Date: September 9, 2025

Re: 25-FTG-135.1
Footing Projection Concerns
Lot 141 Tobacco Road
234 Crop Rd.
Angier, NC 27501
Permit No.: SFD2508-0031

At your request, a site visit was made to the above referenced single family residence under construction to inspect several footing projection concerns noted by the county inspector.

1.01
Foundation Plan
Elevation "D"

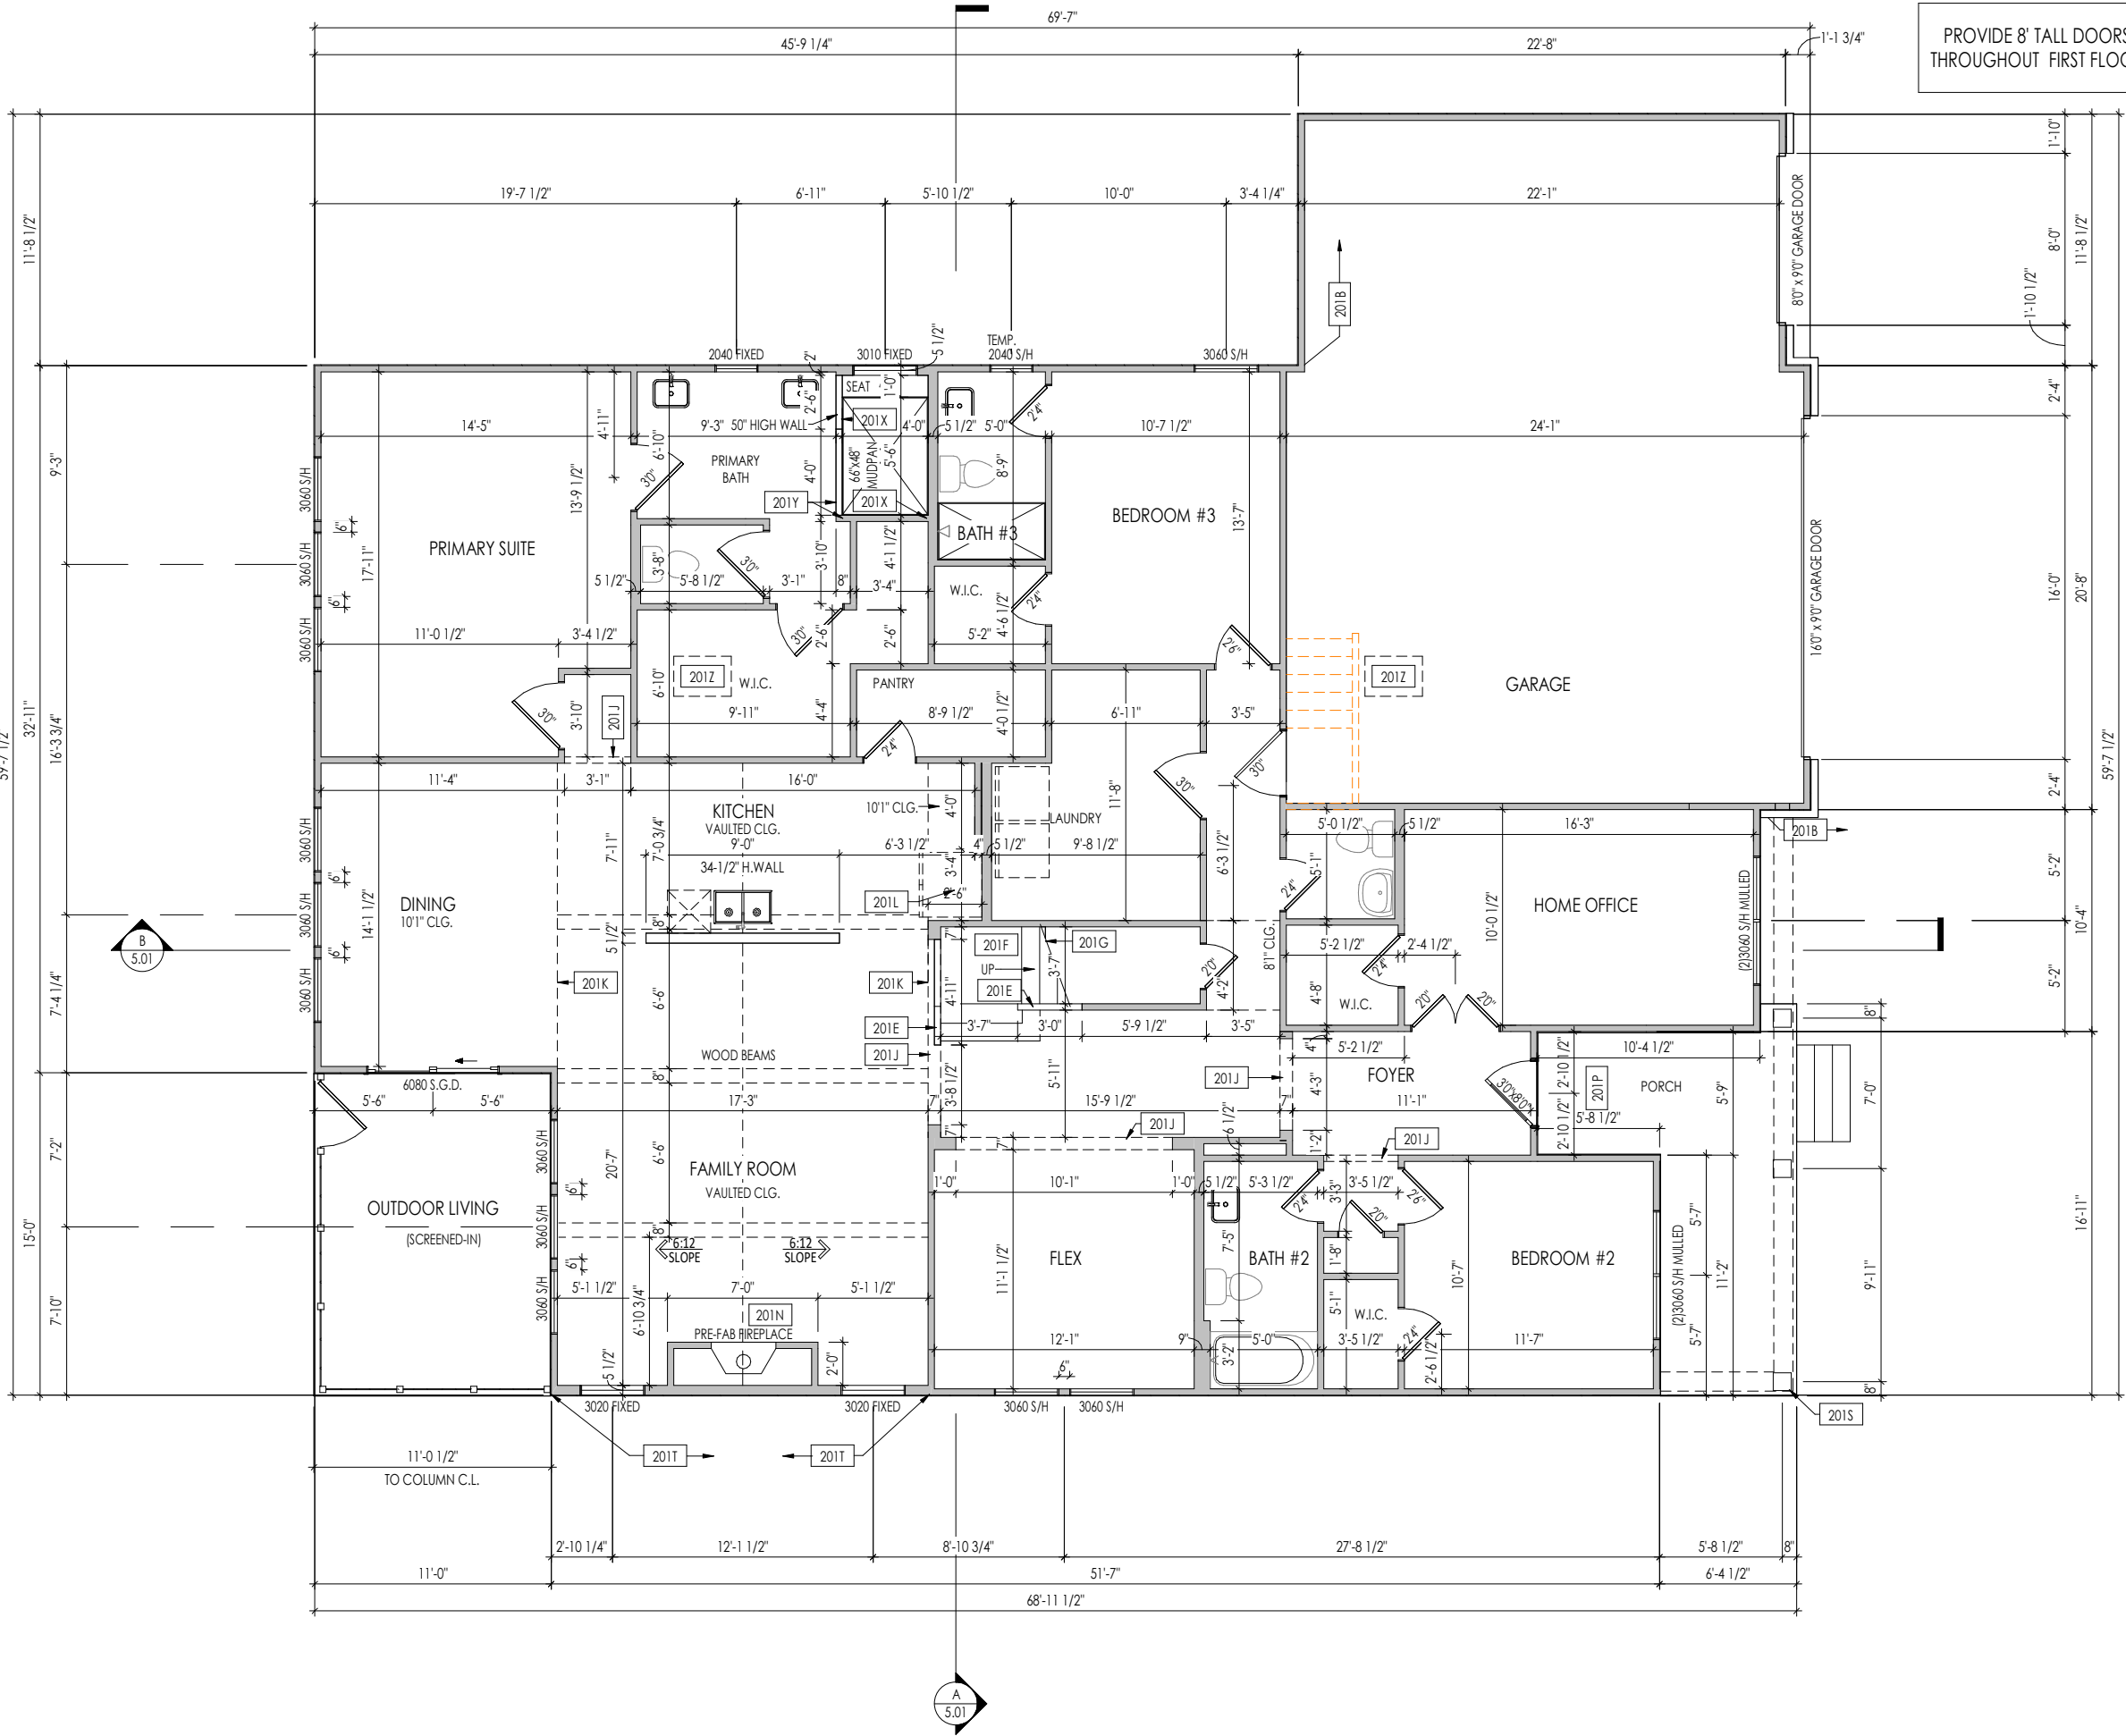
1. Several 16"x16" CMU piers were not located within the center one-third of the footings; however, the piers were verified to have at least 2" of footing projection at all sides.
2. Foundation walls were found to have less than 2" of footing projection at the following locations:
 - a. A +/-3'-0" section at the front side of the rear foundation wall in the one-car garage.
 - b. A +/-2'-0" section at the rear side of the rear foundation wall in the two-car garage.
 - c. A +/-2'-0" section at the rear side of the front foundation wall between the front porch and garage.
 - d. The rear side of the foundation wall at the right rear corner of the front porch.The above noted walls were verified to have full bearing on the footing below.
3. Several CMU piers were found to have footing projection exceeding the thickness of the footings.

1. Analysis revealed the "as-built" pier and footing configurations are adequate and require no modifications.
2. Analysis revealed the "as-built" foundation and footing configurations are adequate and require no modifications.
3. Analysis revealed the "as-built" pier and footing configurations are adequate and require no modifications.
